**EPC Site Plan – SEC 86<sup>th</sup> Street & Bridge Blvd SW****Applicant Comment Response Memo for:****CONDITIONS OF APPROVAL**

Project #: 2020-004098 / SI #: 2024-01284 - Site Plan – EPC

GRADING PLAN

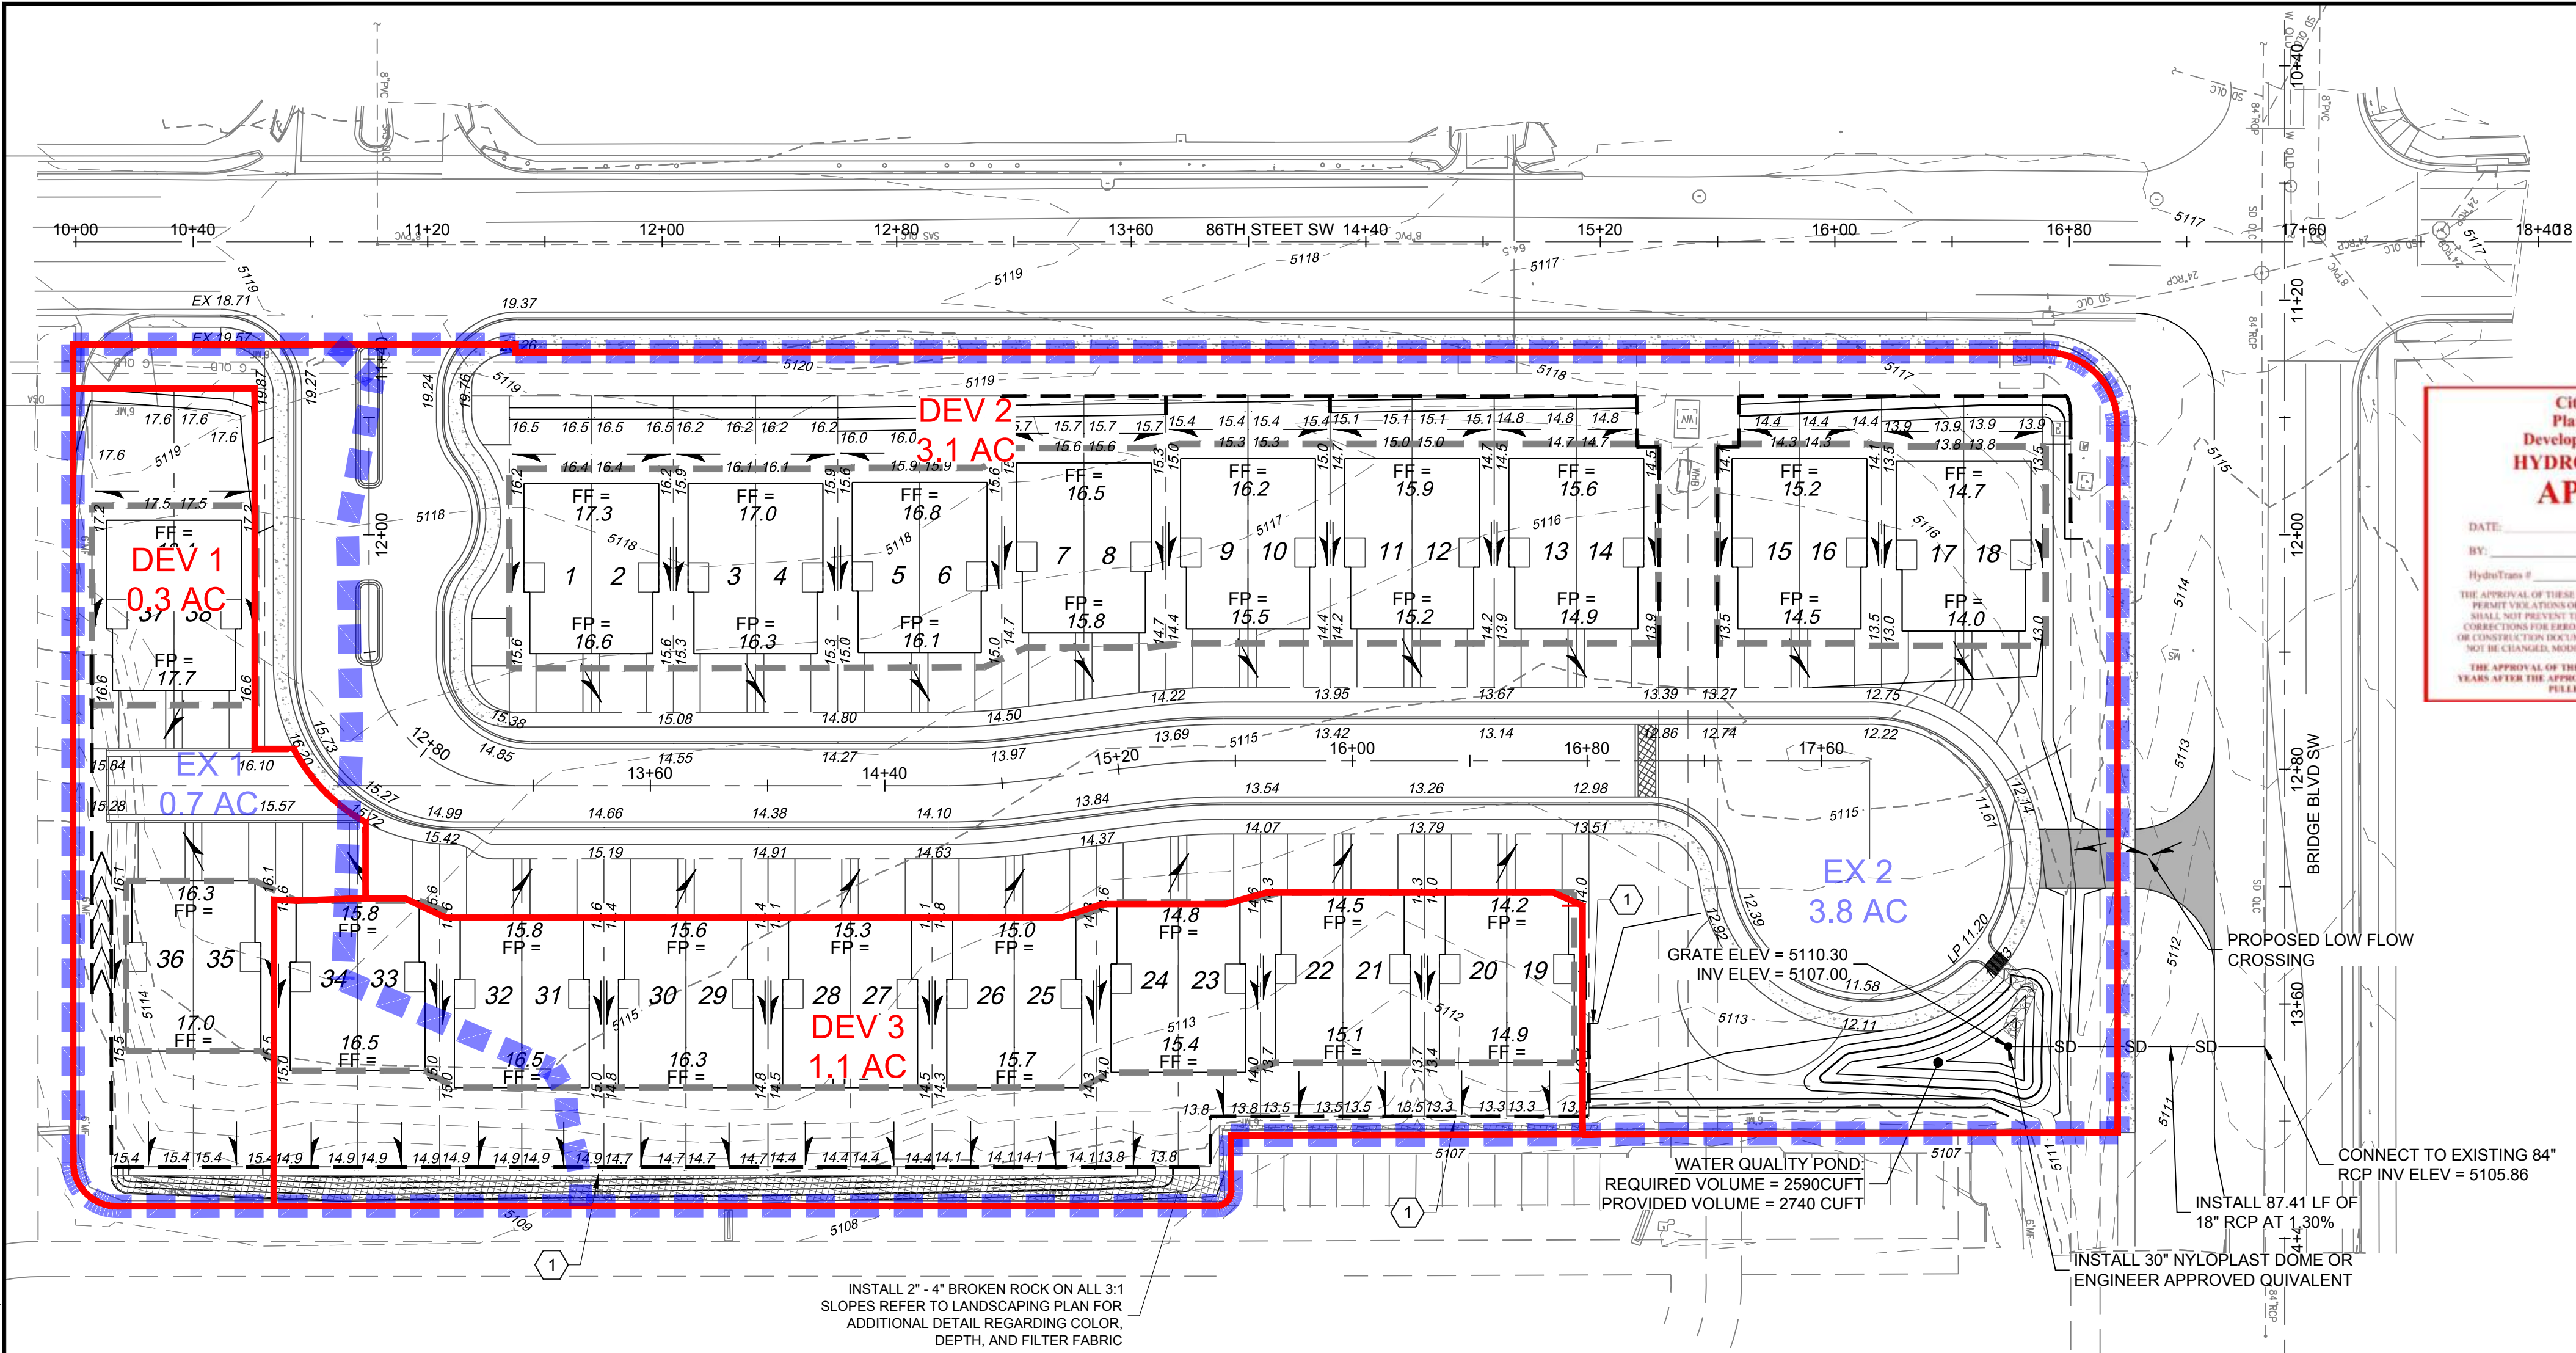
A. The GRADING PLAN shall be renamed GRADING AND DRAINAGE PLAN

B. The GRADING AND DRAINAGE PLAN NARRATIVE shall be revised from saying the “development will drain to the northwest corner of the site” to state

“development will drain to the northeast corner of the site.”

C. Detail Section A-A shall be removed. It is located on the detail sheet.

D. The NOT FOR CONSTRUCTION stamp shall be removed.

*Applicant Response – Revisions have been made.*

NAME: P:\246101 Ashland Bridge and 86th\3. DWG\4. Exhibits\C-102 Utility Plan.dwg Plotted: Jan 08, 2025 10:54am

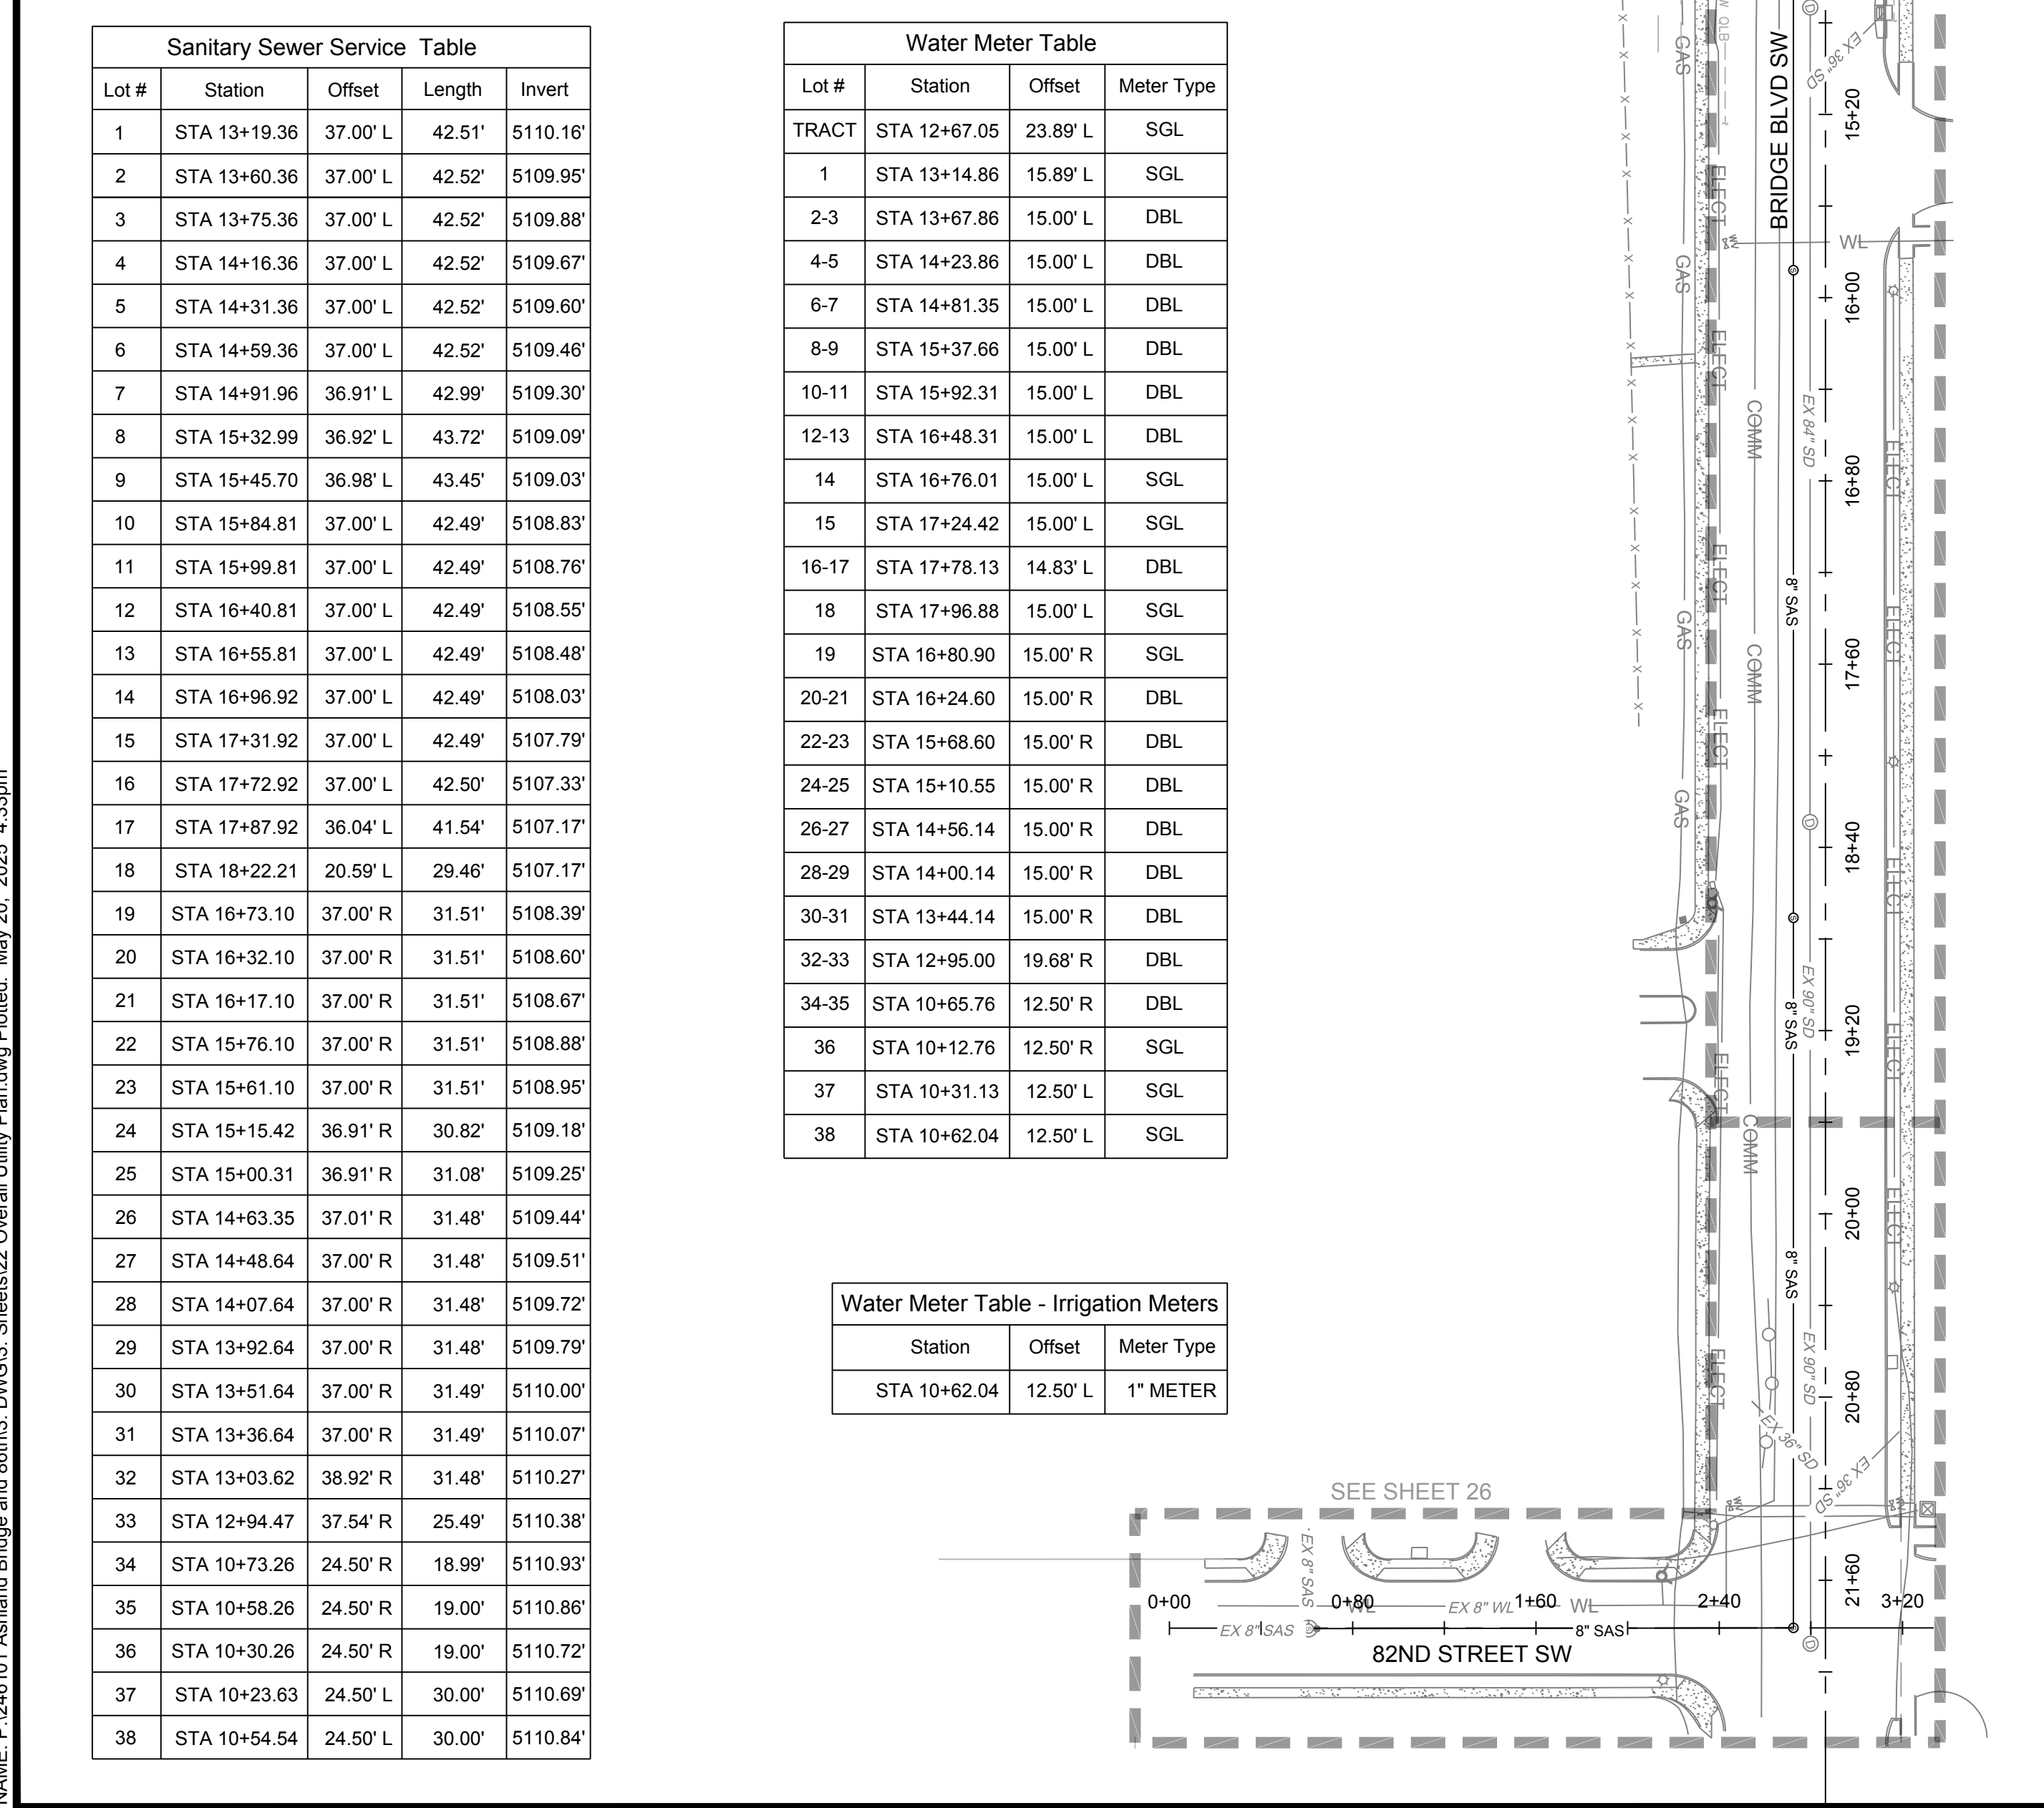
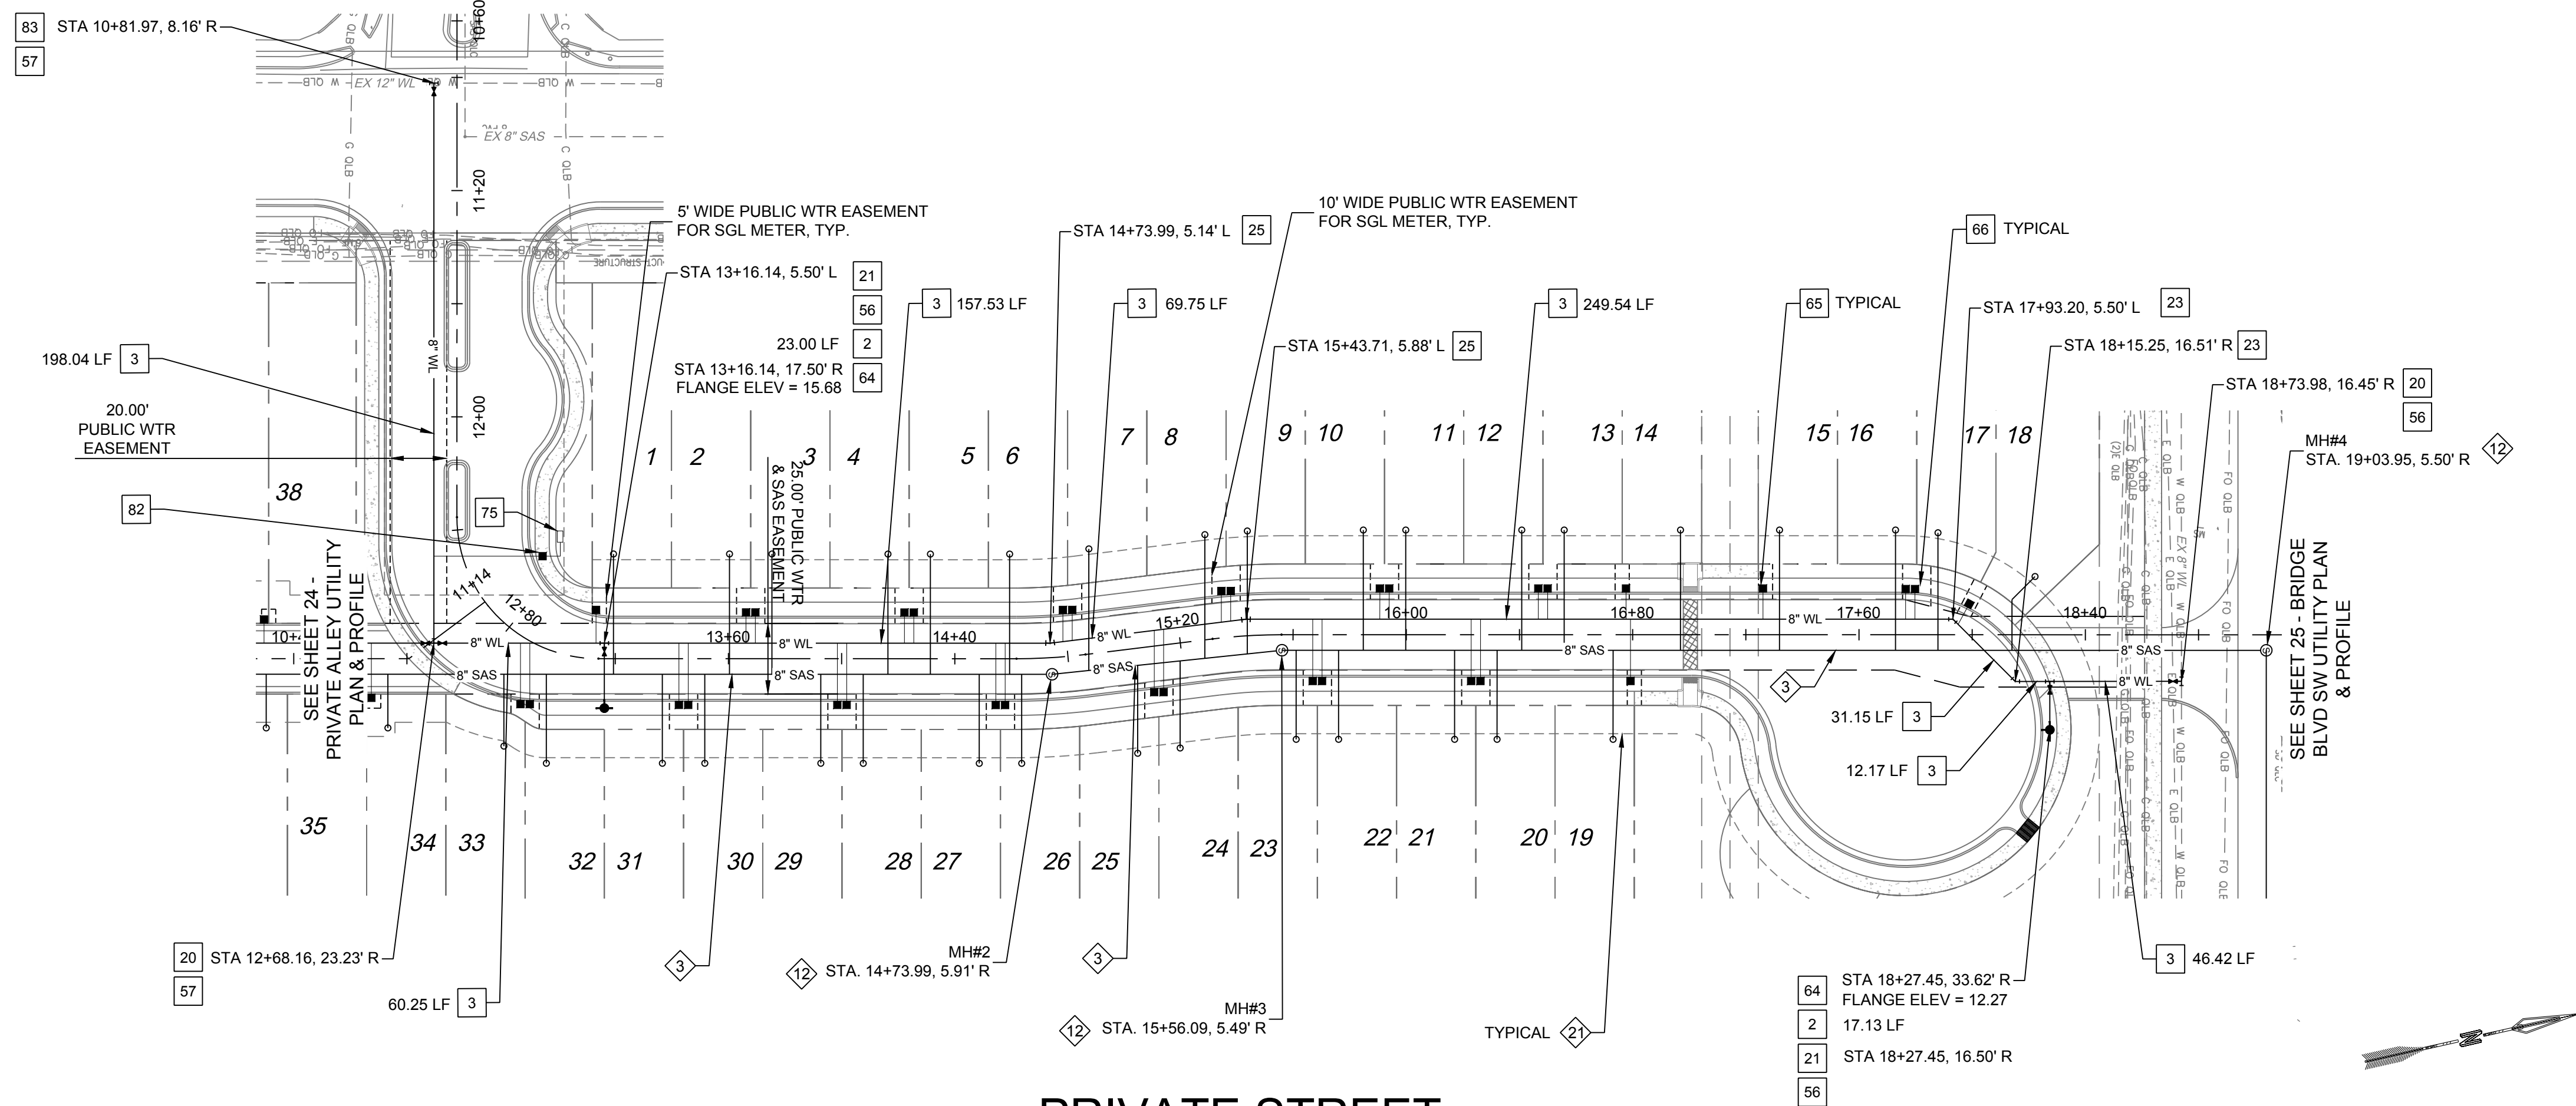
A. The word CONCEPTUAL shall be removed from the title of the sheet.

B. The NOT FOR CONSTRUCTION stamp shall be removed.

*Applicant Response – Revisions have been made.*
